Our Ref: SSD 8859

**Request for Additional Information
Elizabeth Drive Business Hub, Cecil Park (SSD 8859)**

The Department has reviewed the Development Application (DA) and environmental impact statement (EIS) for the Elizabeth Drive Business Hub that was lodged on 14 August 2018, in consultation with Fairfield City Council and relevant agencies.

drg title	
SITE PLAN	
drawn	checked
SB	RD

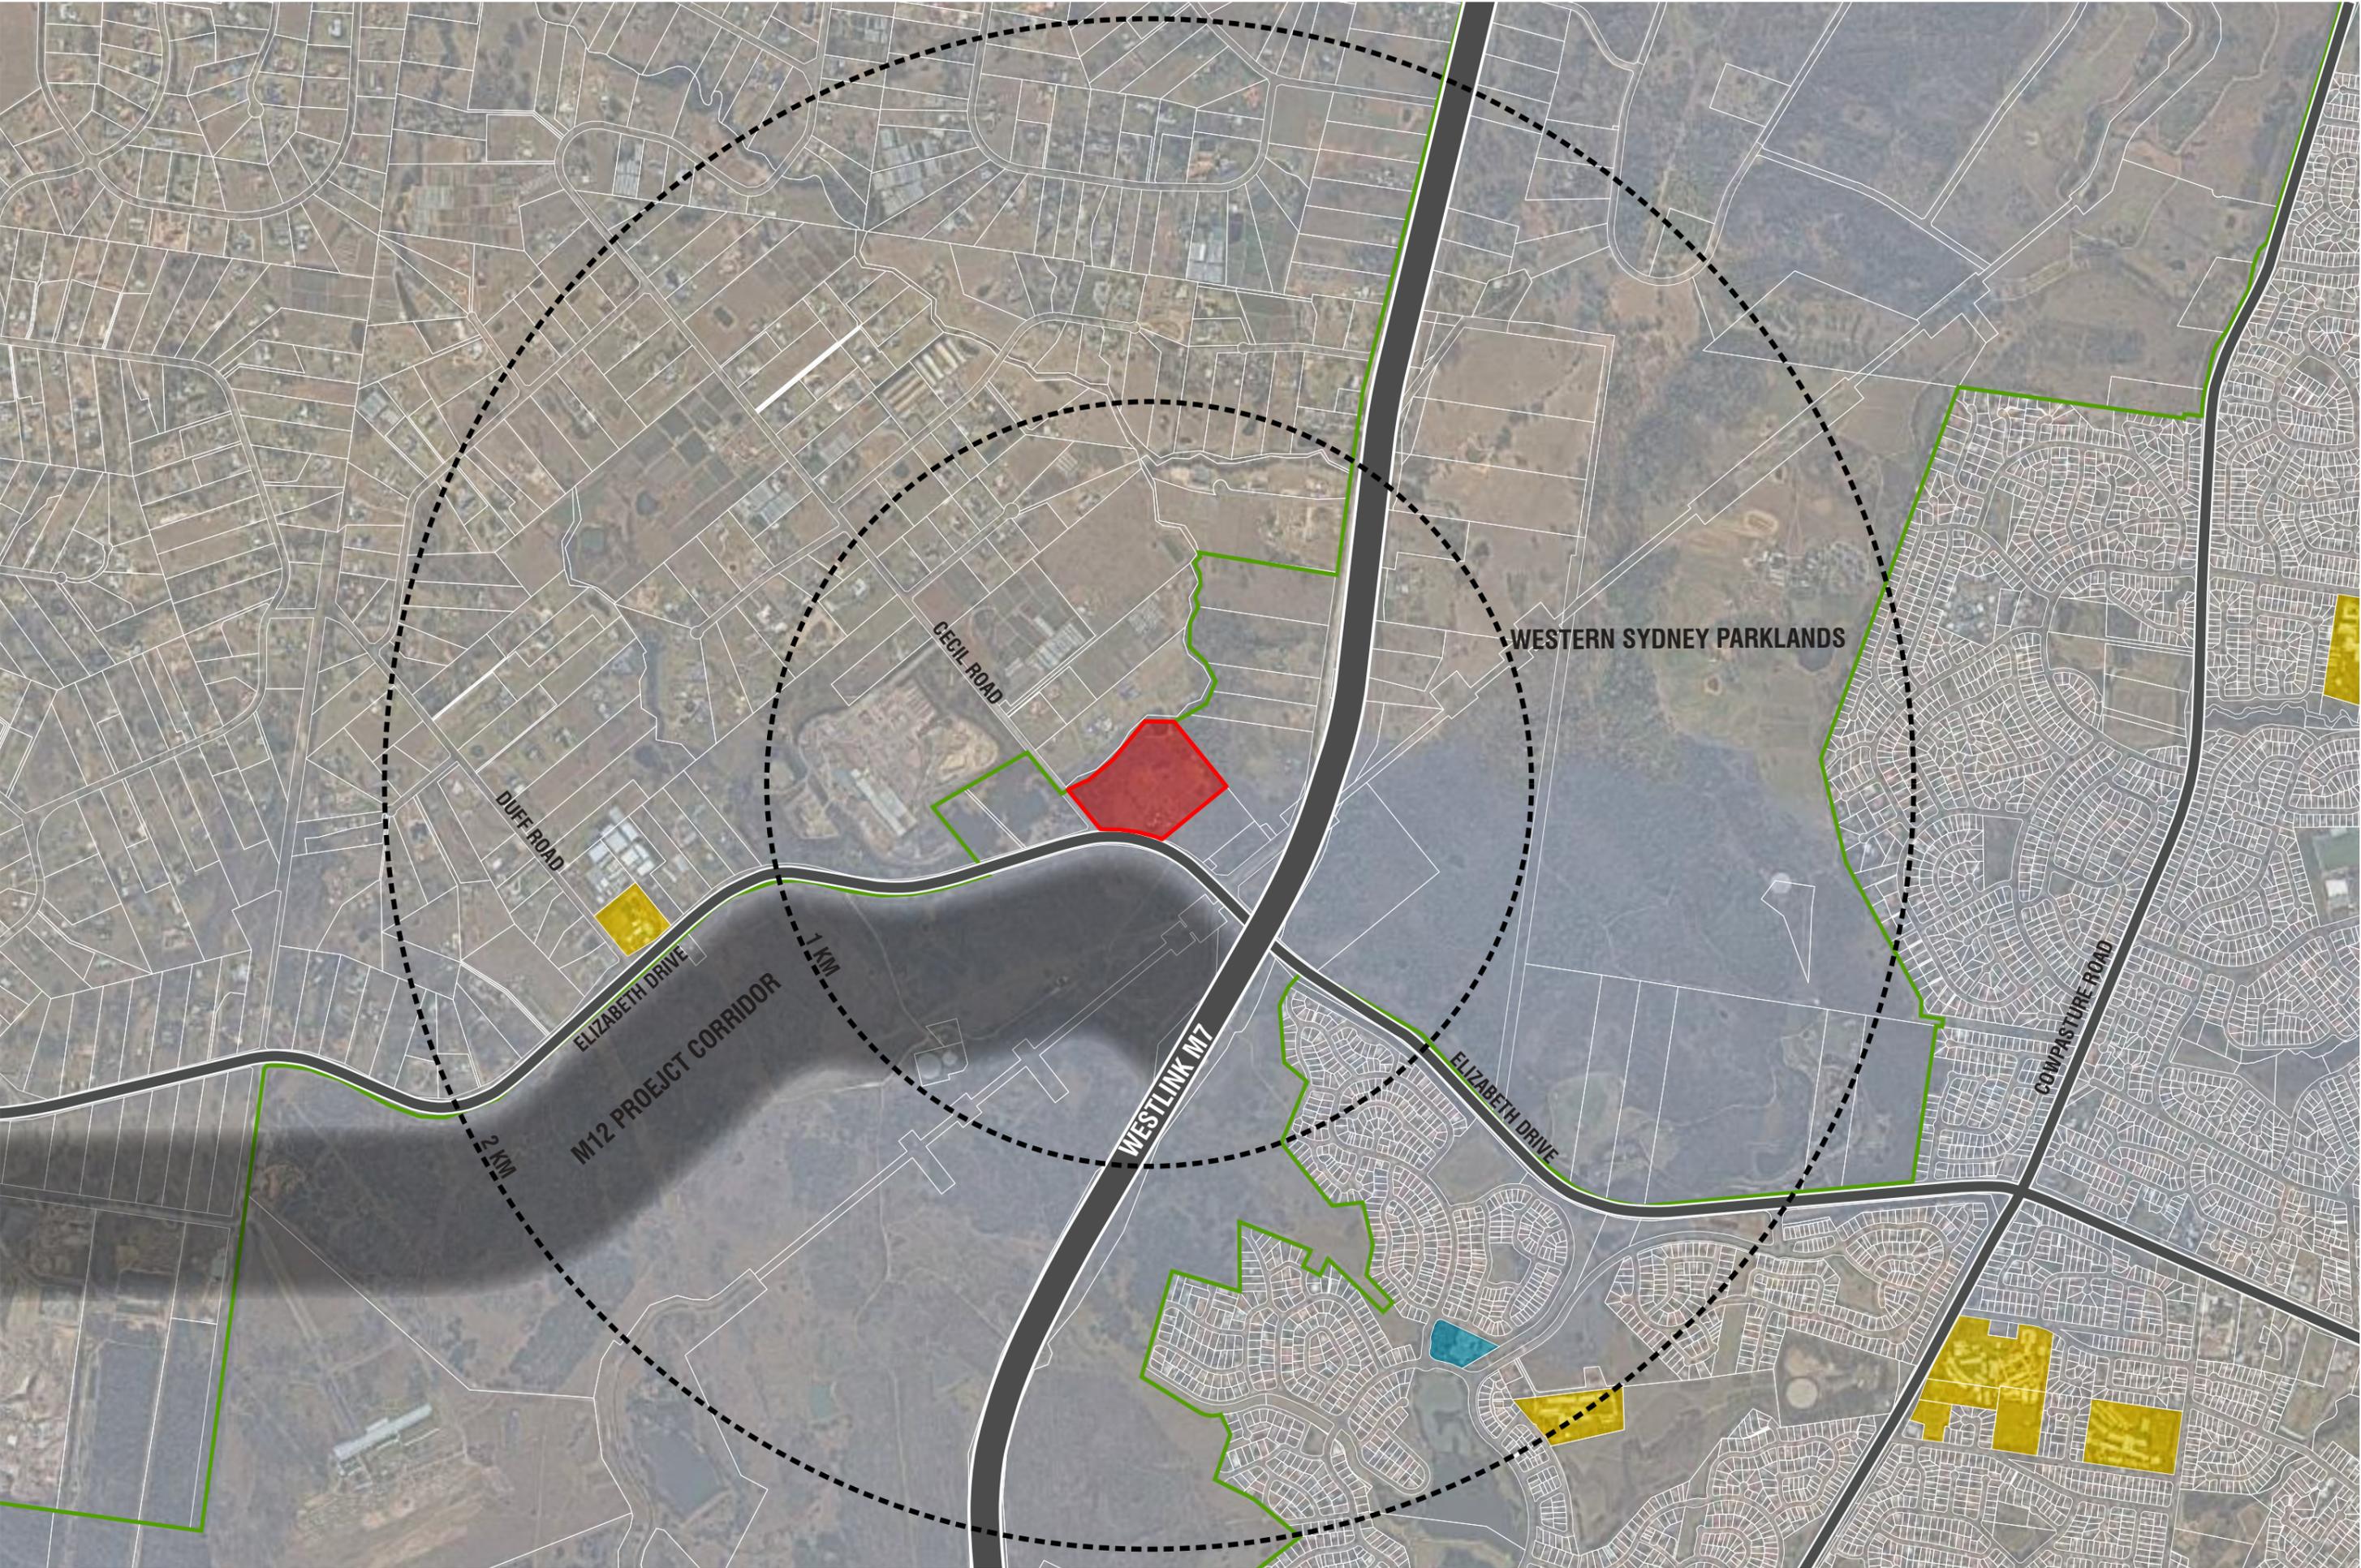
Infrastructure upgrades or items required to facilitate the development and a description of any arrangements to ensure upgrades will be implemented in a timely manner and maintained	The plans submitted show that a roundabout is proposed at the Elizabeth Drive and Cecil Road intersection. However, this is not mentioned in the body of the EIS nor does the EIS outline the timing for the delivery of road upgrade works in general. The EIS must clearly outline the required infrastructure upgrades and the expected timing for the completion of all infrastructure upgrades.
Consideration of all relevant environmental planning instruments	Refer comments below in relation to Strategic Context.
<p>The EIS must also be accompanied by a report from a qualified quantity surveyor providing:</p> <ul style="list-style-type: none"> - an estimate of the jobs that will be created by the development during the construction and operational phases of the development 	Section 6.6.4 of the EIS states that the operation of the site will generate 233 jobs. However, the CIV report does not provide an estimate of jobs generated by the proposed construction works.

DRAWING TITLE				
PAVEMENT PLAN				
PROJECT NO.	PLANSET NO.	RELEASE NO.	DRAWING NO.	REVISION
P1706121	PS02	R03	PS02-G400	A

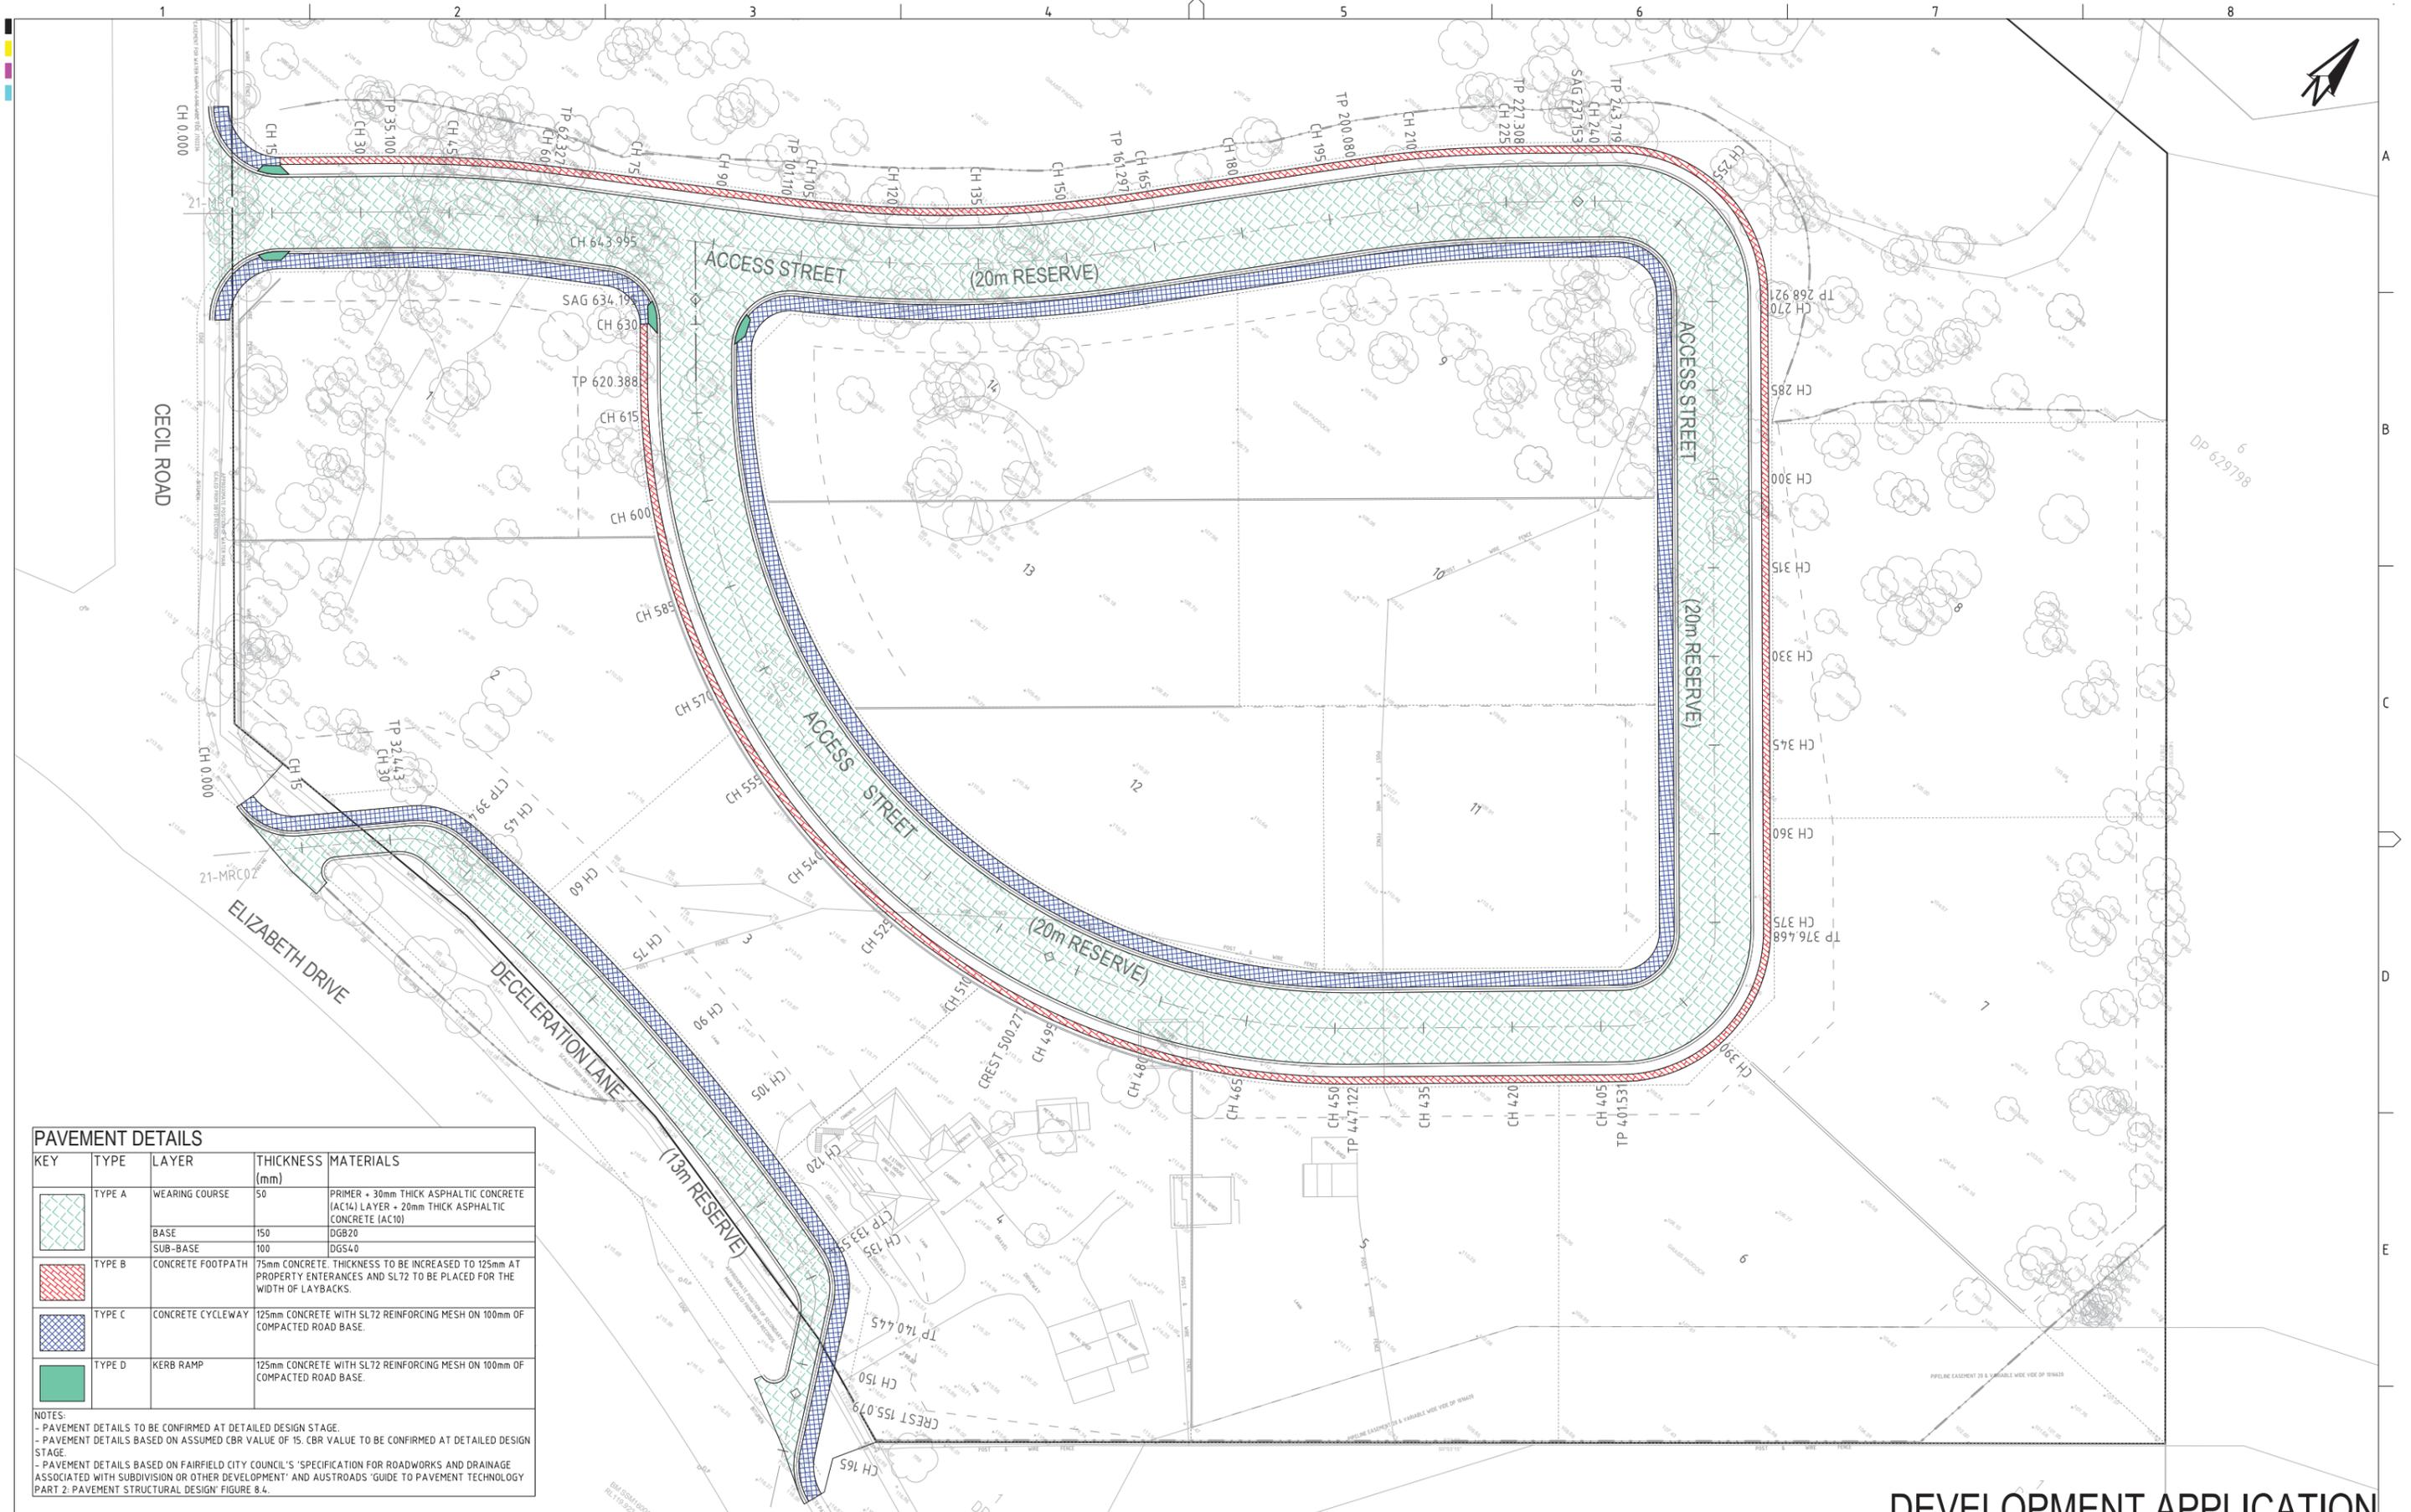
Figure 4 of the EIS identifies the proposed M12 motorway will be located directly to the south of the site. However, there is no discussion of this in the EIS. The EIS must include a description of all proposed developments in the vicinity of the site to understand how the locality may change in the future and any interactions between this proposal and the M12 motorway.
Plans of any proposed works	<p>As outlined in Attachment 1 of the SEARs, the plans must include a locality/context plan which identifies significant local features (including nearby sensitive receivers), the location of existing buildings and any public transport nodes. Please provide a locality/context plan as requested in the SEARs.</p> <p>Refer to comments on Stormwater Management Plan below.</p> <p>The 'Earthworks Grading Plan', the 'Earthworks Cut-Fill Plan', 'Pavement Plan' and 'Retaining Wall Plan' are in draft form. Provide final copies of these plans.</p>
